CONSULTATION RESPONSE

Application No. 2021/92347 – Residential Development Proposal Adj. 3 Elm Street, Skelmanthorpe

EXISTING SITE PLAN 1:100 @ A1

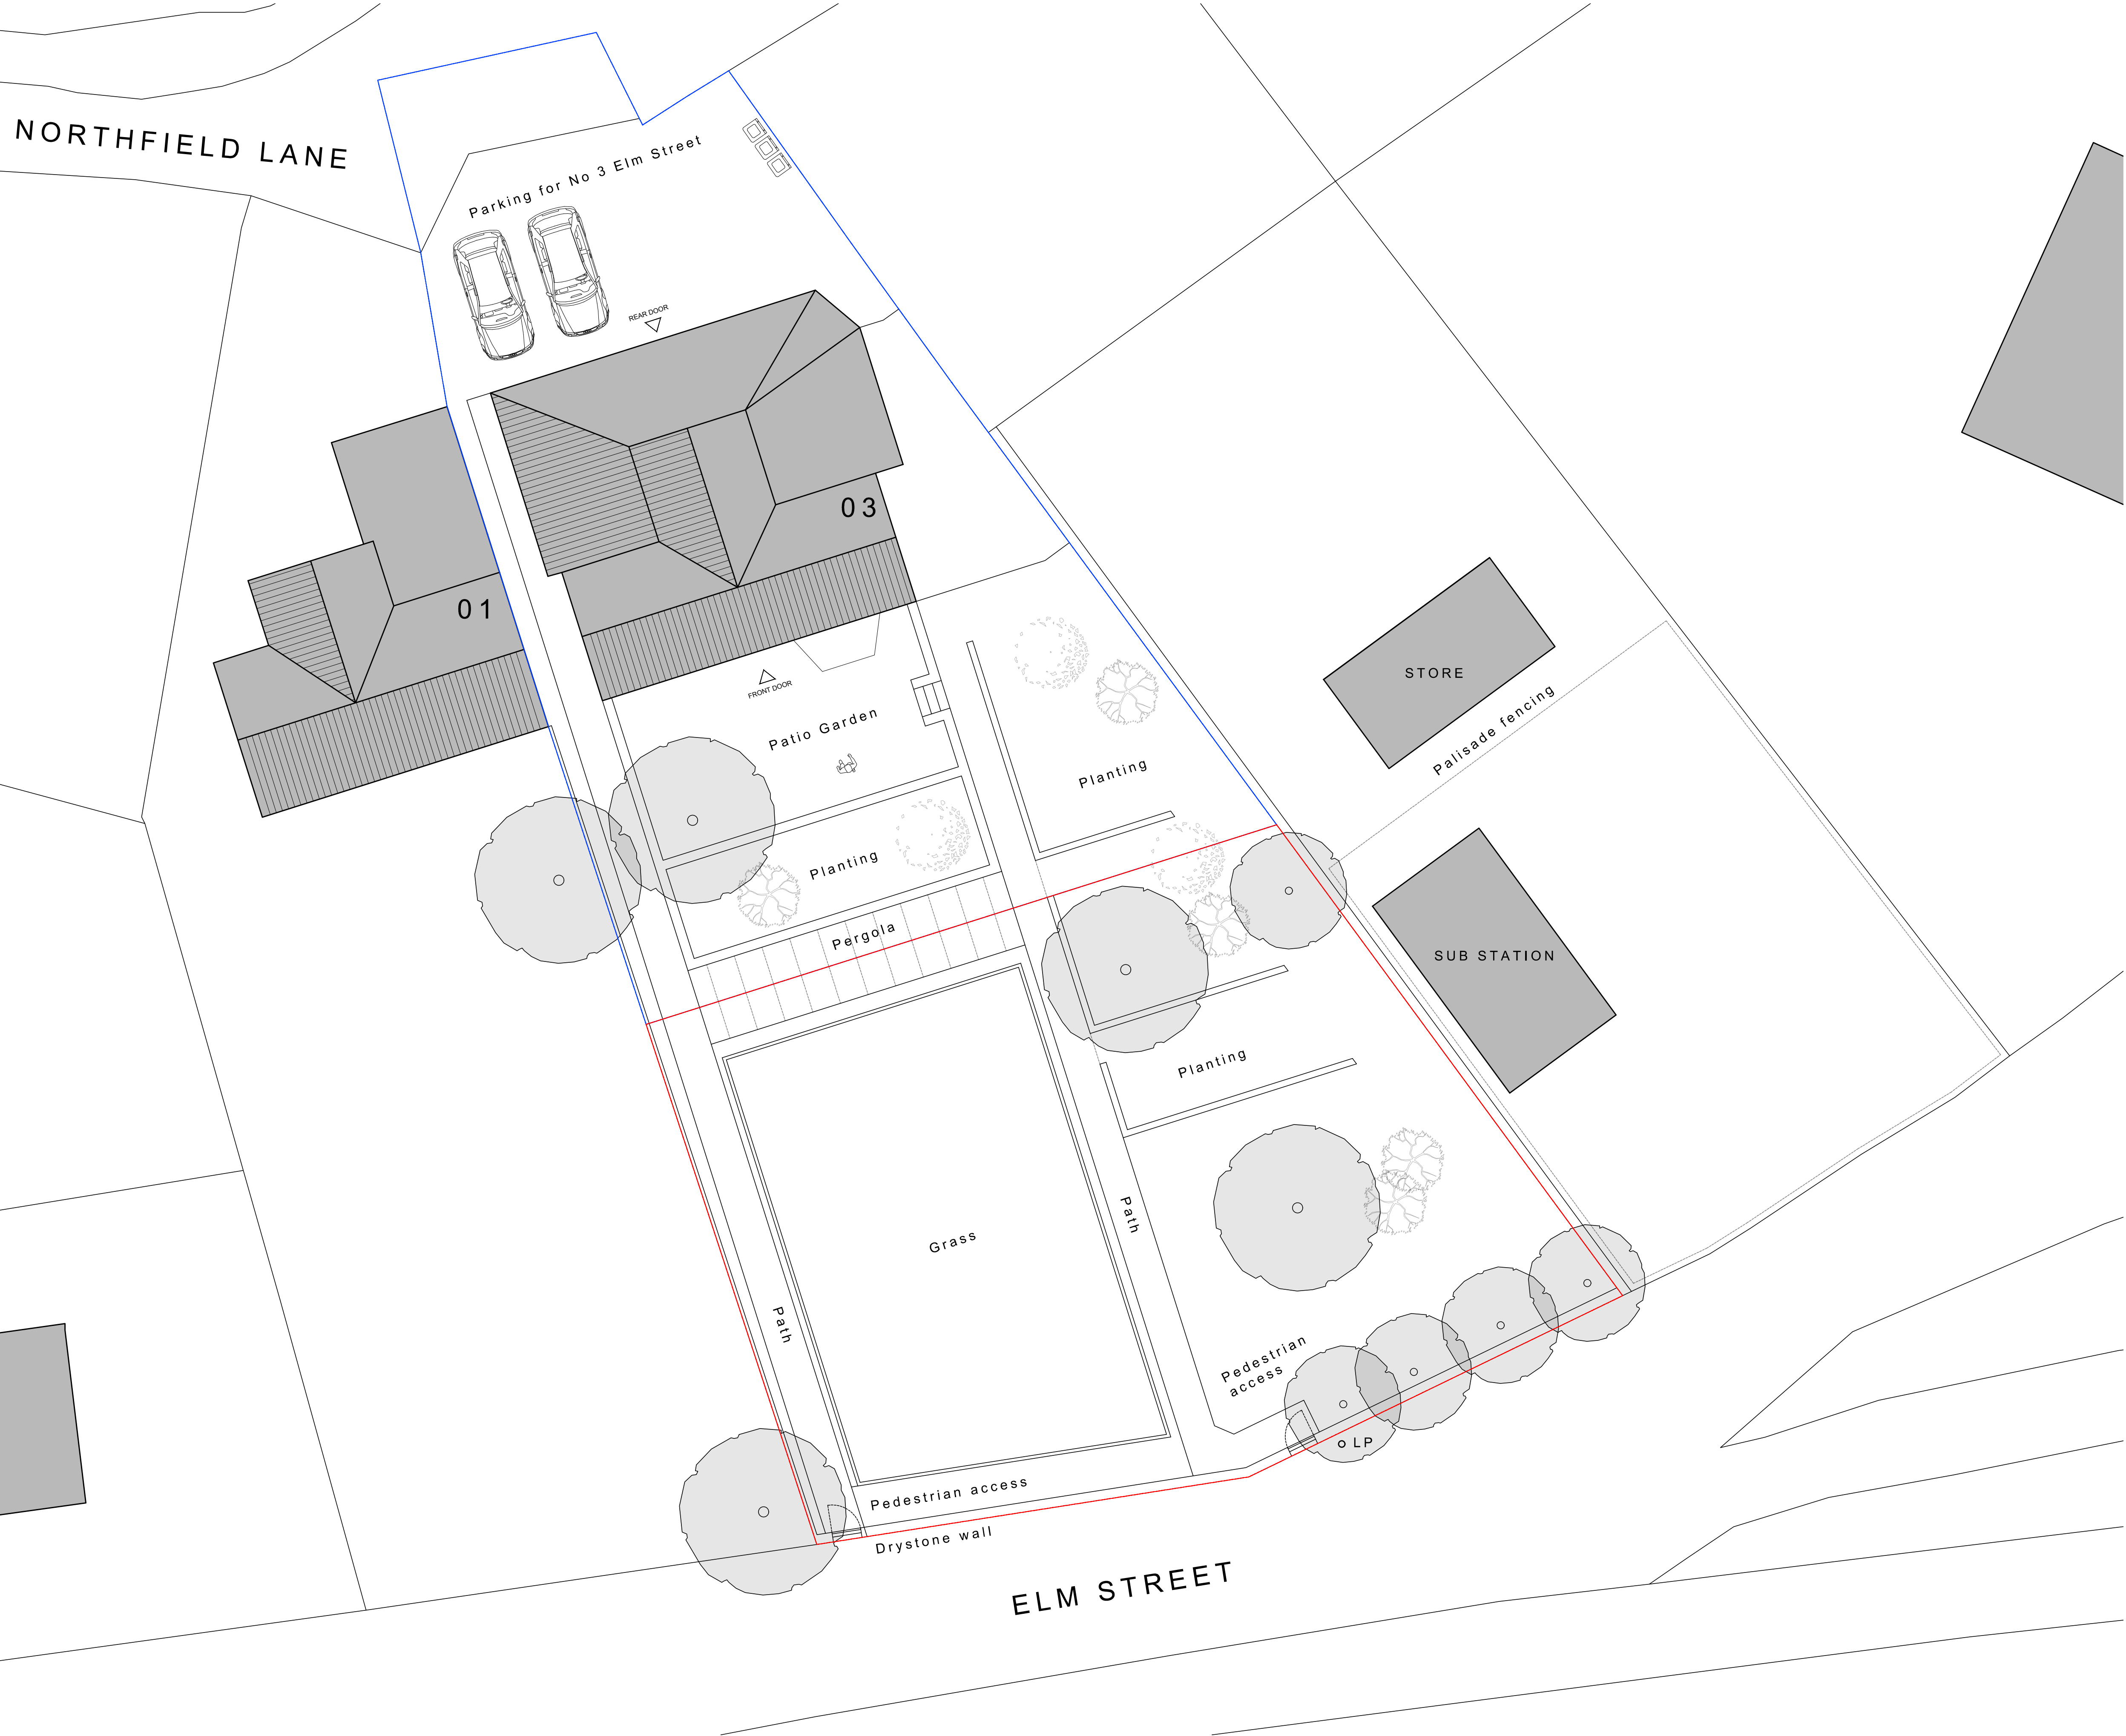
- **Access and traffic issues** – Elm Street is a narrow tarmacked lane, originally part of the old road to York and the main road into Skelmanthorpe before the steep walled banking (directly in front of the proposed site) was built around the 1850's to carry what is now Commercial Road. At the proposed site, there are no public footpaths on any side of the road, it is narrow and on a bend which cuts visibility.

To have two driveways where vehicles will have to drive in/back out (as there is no turning space within the site) on a bend on this narrow road is totally unacceptable. Any construction traffic will find access extremely difficult, if not impossible, and will block the road. It will be noted that vehicular access to Nos.1 and 3 Elm Street is, in fact, via Northfield Lane.

- The proposals will involve the felling of conifer trees and a mountain ash tree and the destruction of a garden area - again to the ruination of amenity value of the area and, we would have thought, against the Council's 'green' policies and work towards a Zero Carbon future.
